OUT18/929

**Bengalla Continuation Project Modification 4 (SSD 5170 MOD 4)  
Request for comment on Statement of Environmental Effects**

Alison Collaros  
**A/Manager, Assessment Advice**  
1 February 2018

MOD4 Conceptual Year 4 Mine Plan

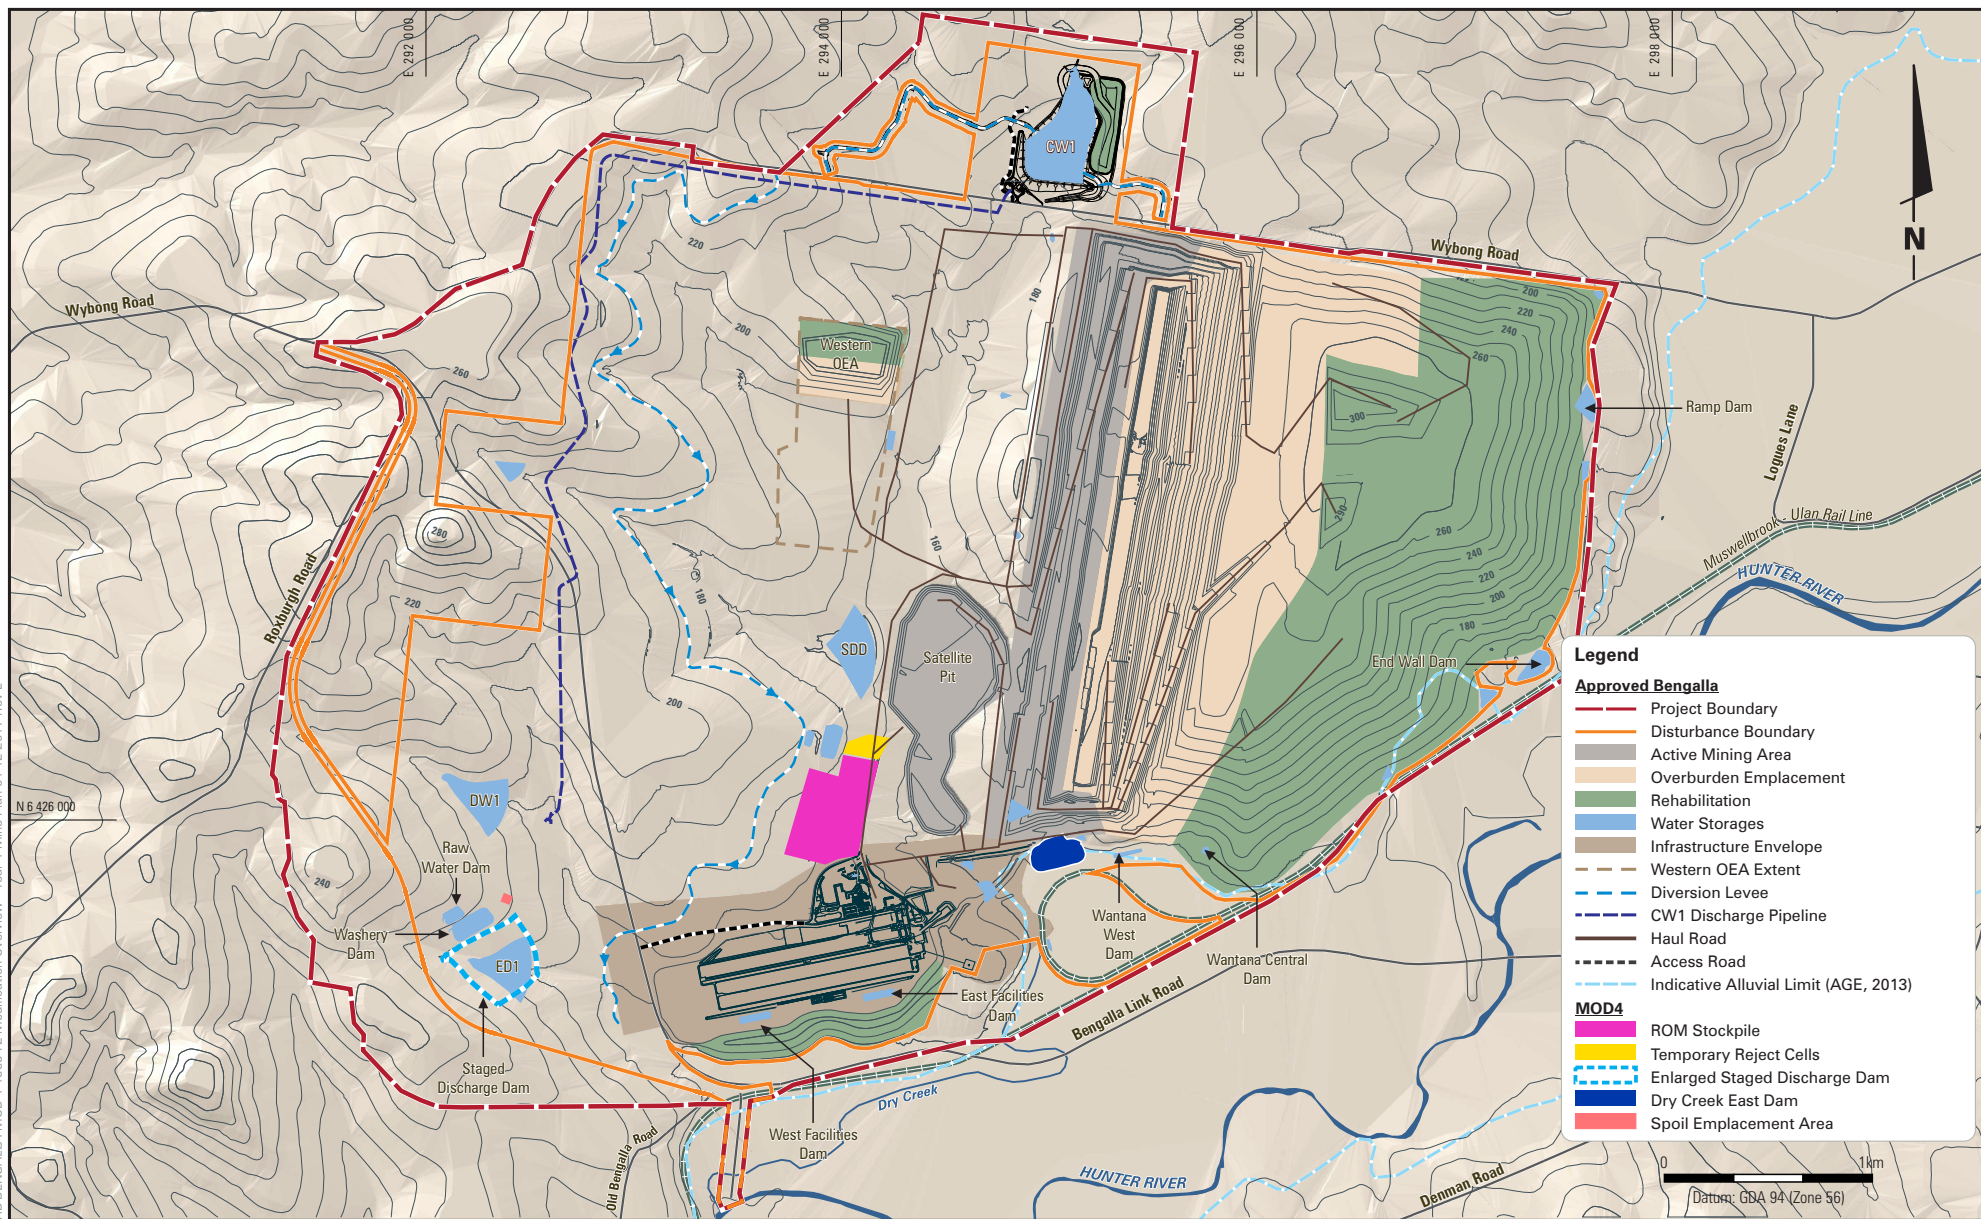
- 1 That the proponent be required to install a shallow alluvial monitoring bore down gradient of the new Dry Creek East Dam and include in the Water Management Plan.
- 2 That the proponent be required to update the Water Management Plan in consultation with Dol Water.

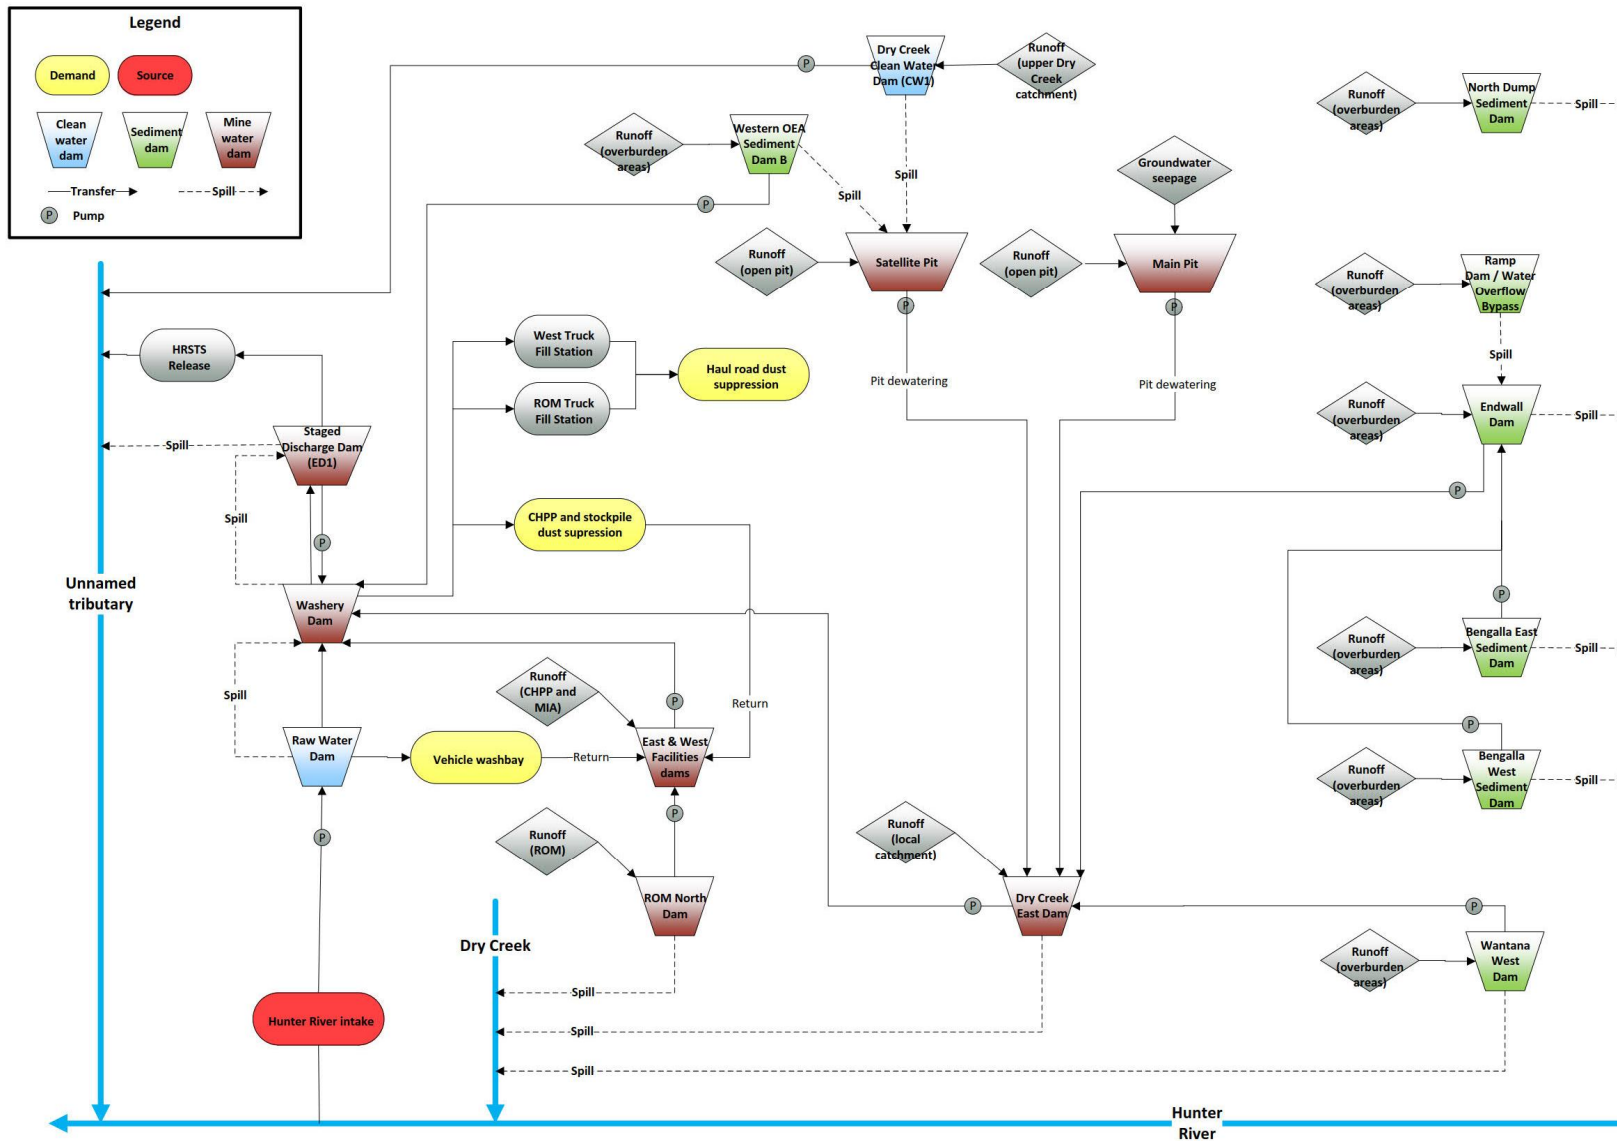
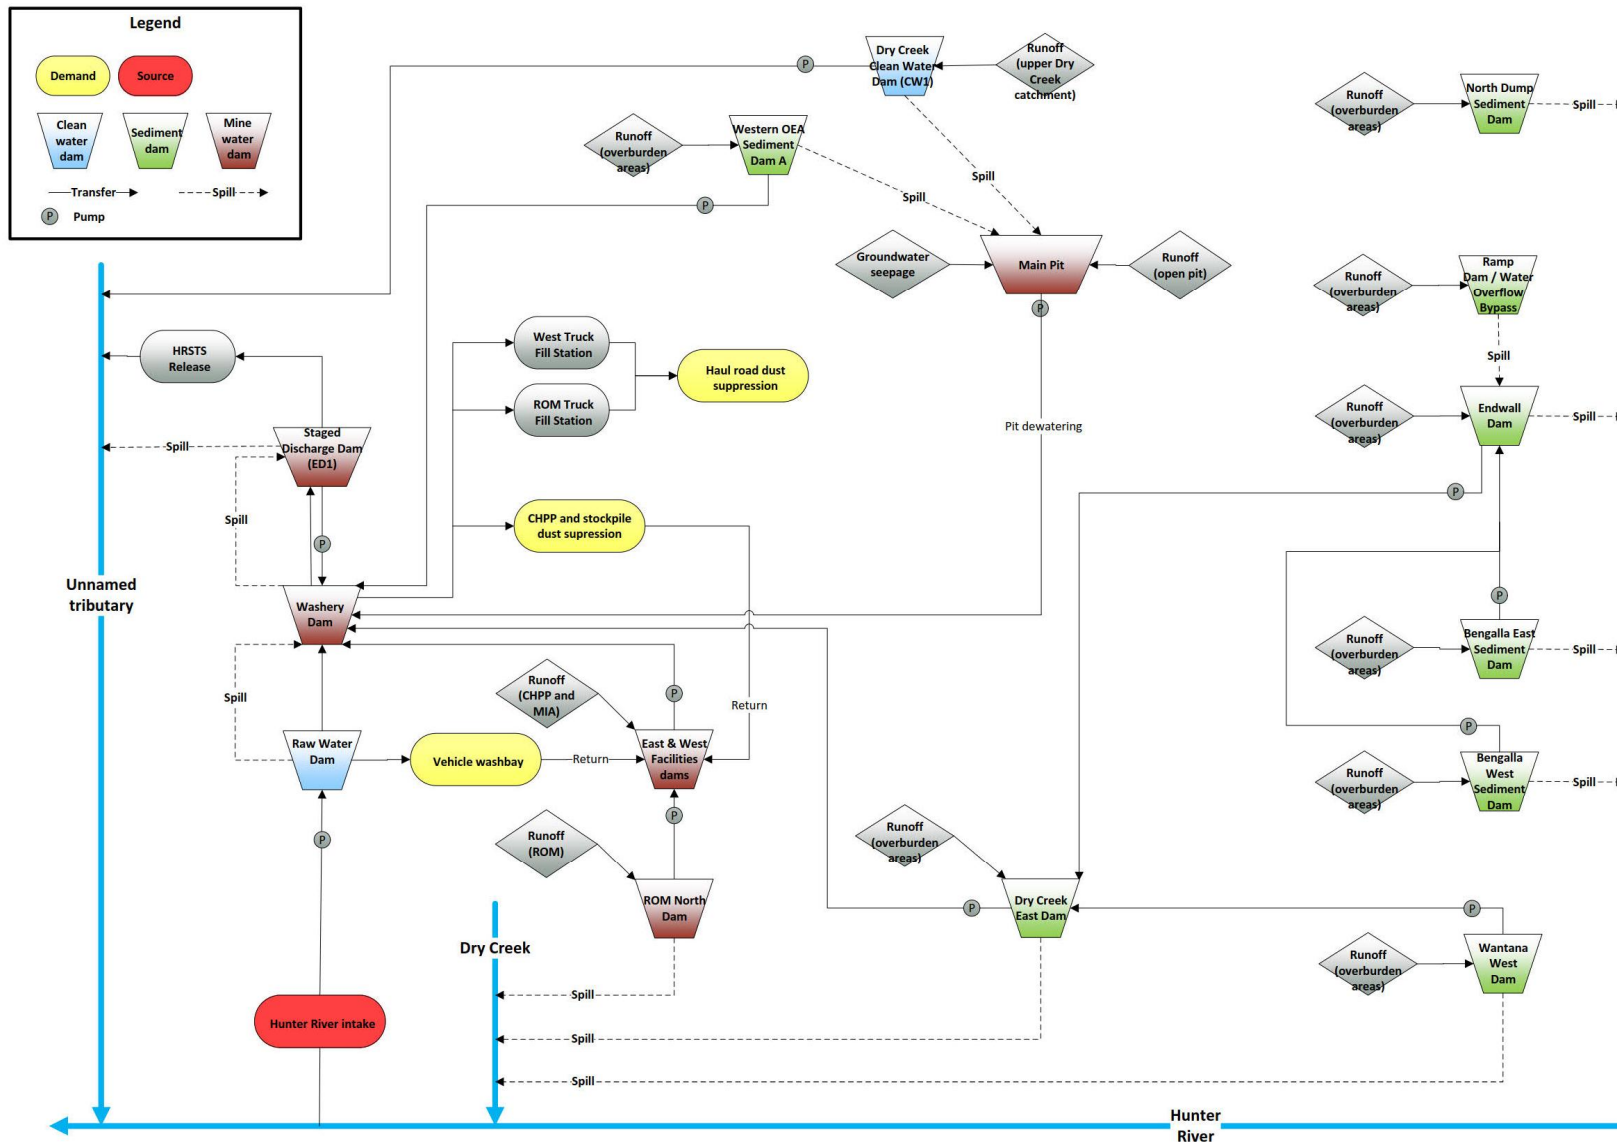
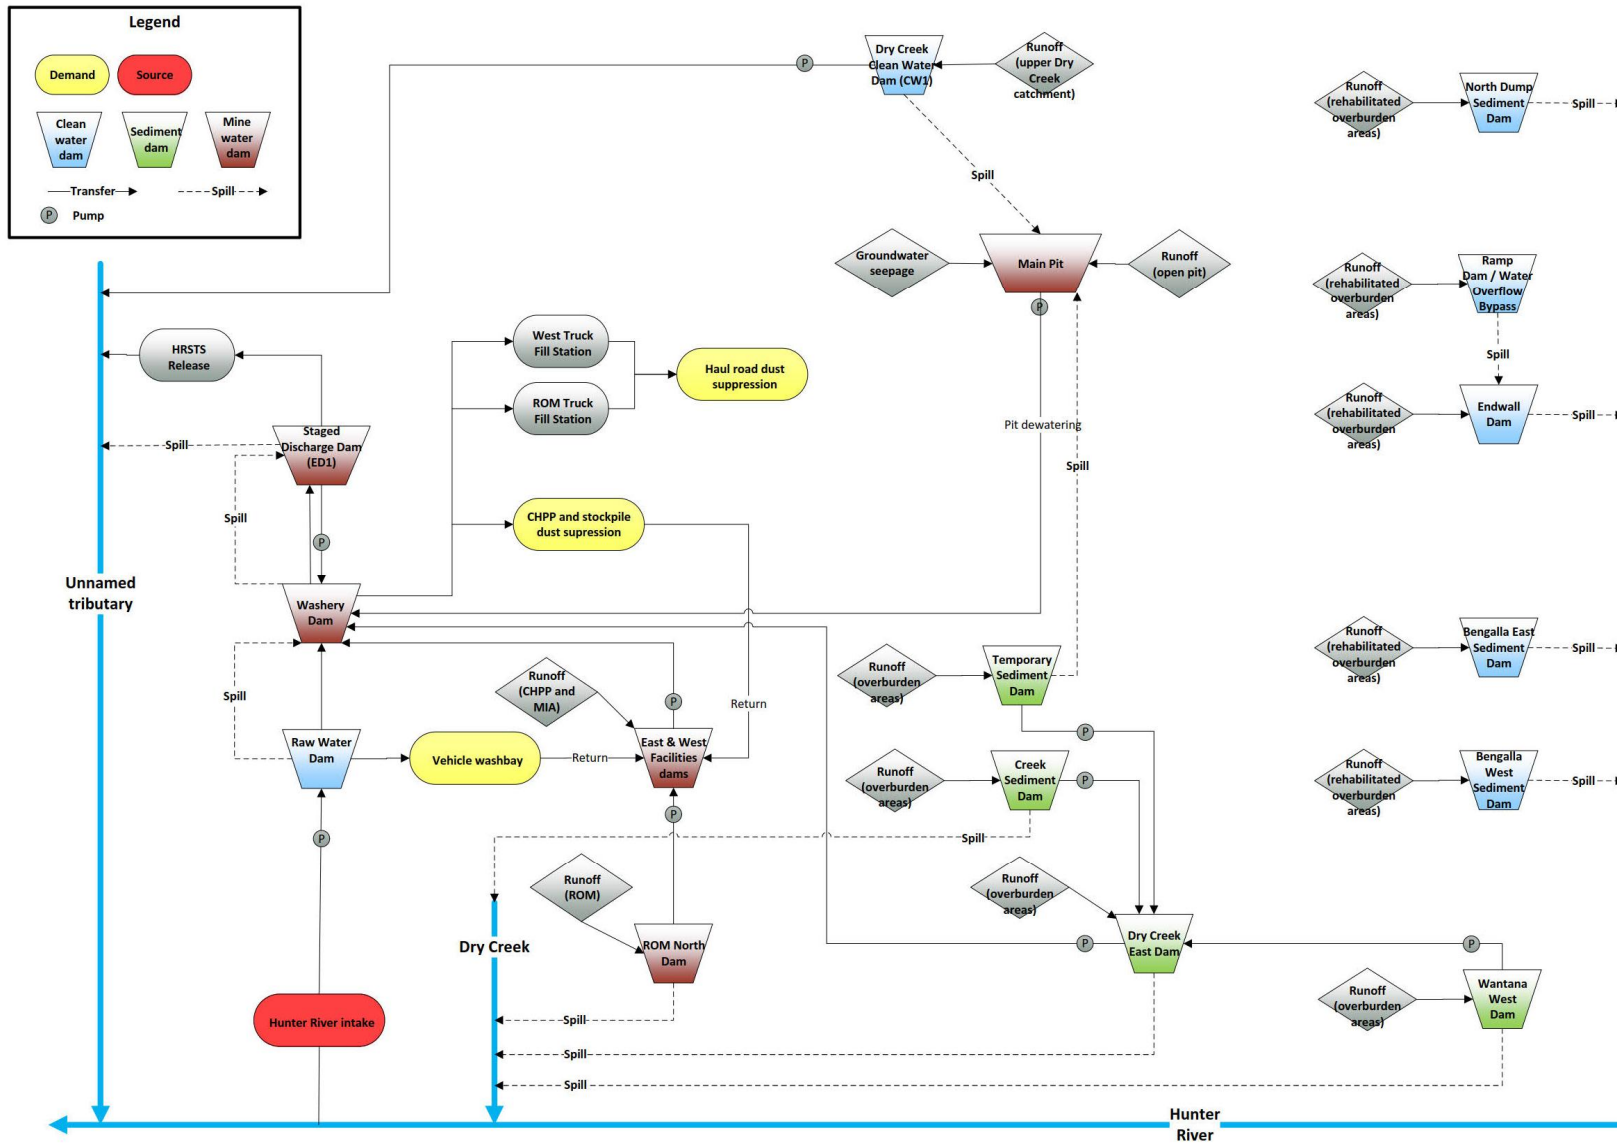
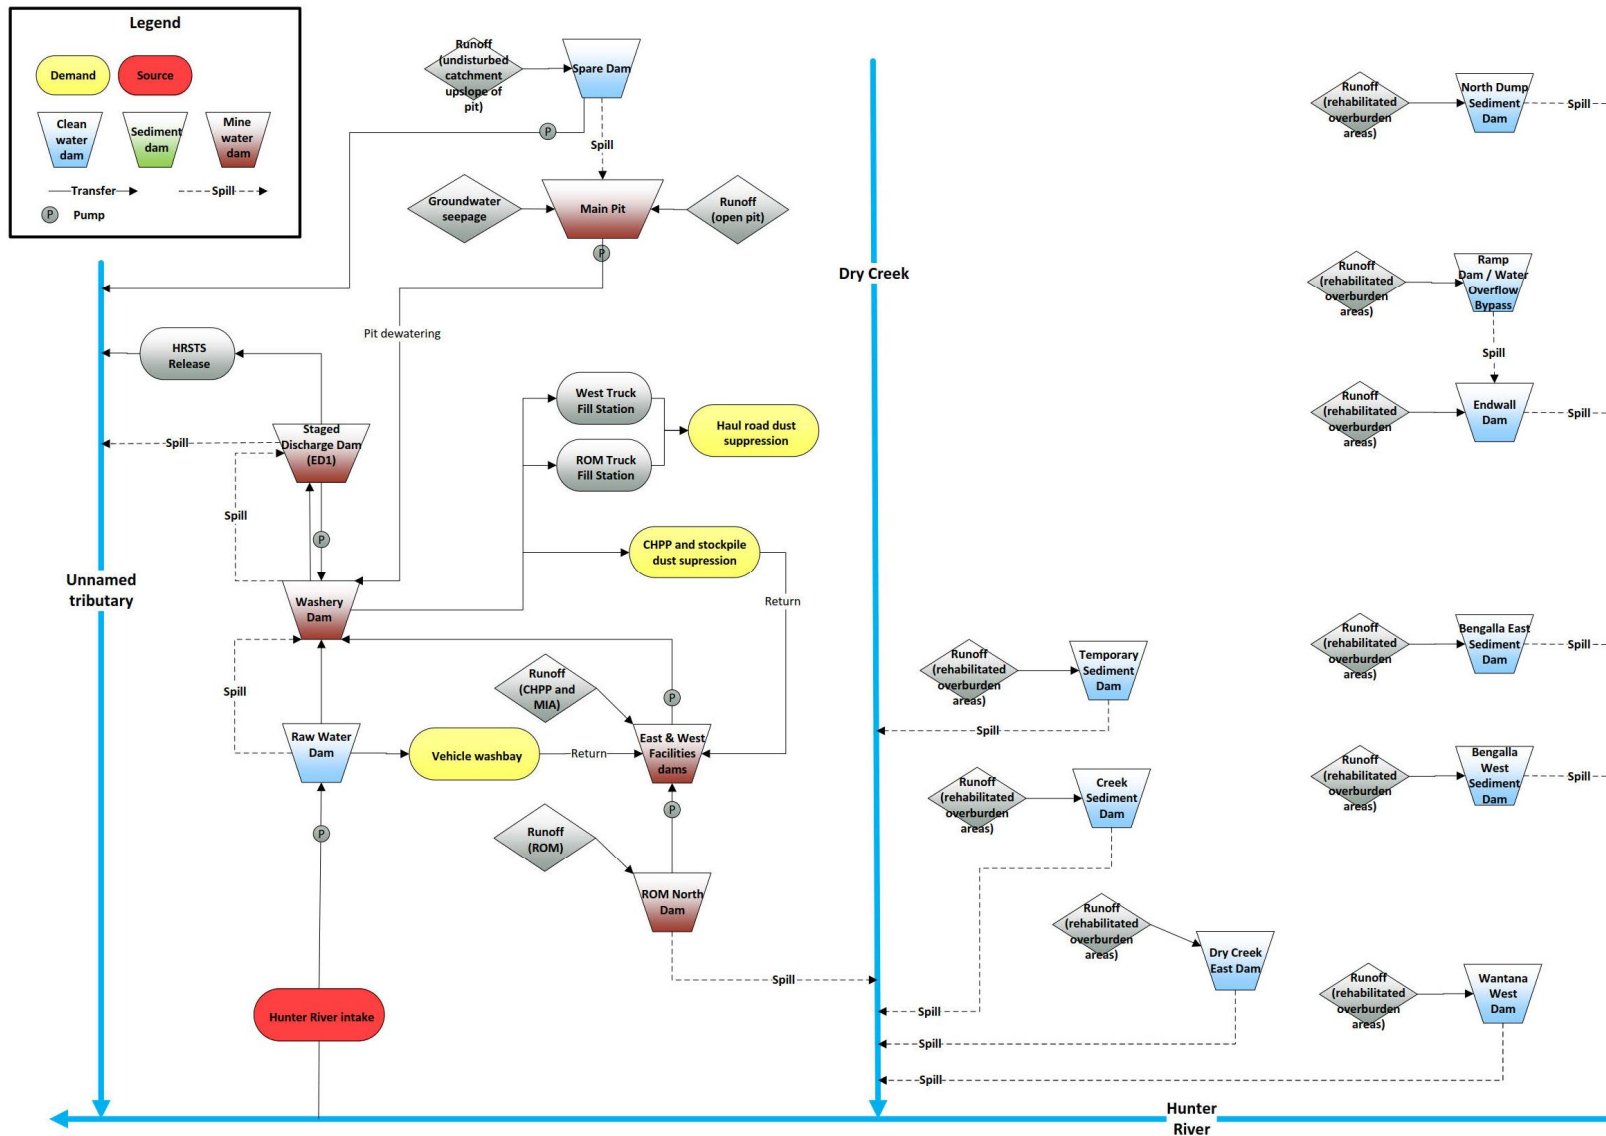
Further information will be required in the amended Water Management Plan on how the following dams will be operated (years 15 onwards) and how these dams will be appropriately licensed or accounted for: future raw water dam, Endwall Dam, Bengalla East Sediment Dam (Homestead Dam), Bengalla West Sediment Dam (Farm Dam), Ramp Dam, Dry Creek Clean Water Dam 1 (CW1), North Dump Sediment Dam.

Table 4.2 of the Surface Water Assessment indicates that the surface water management system will include a number of clean water dams at years 15 and 24 (previously sediment dams in subsequently rehabilitated areas). Because these are indicated to be clean water dams, the volume of water held would need to be accounted for. It appears that these clean water dams would exceed harvestable rights.

Whilst the operation of these dams does not appear to have been changed under the proposed modification, it is recommended that the proponent provide further information within the amended Water Management Plan on operation of these dams at years 15 and 24 and how these dams will be appropriately licensed or accounted for.
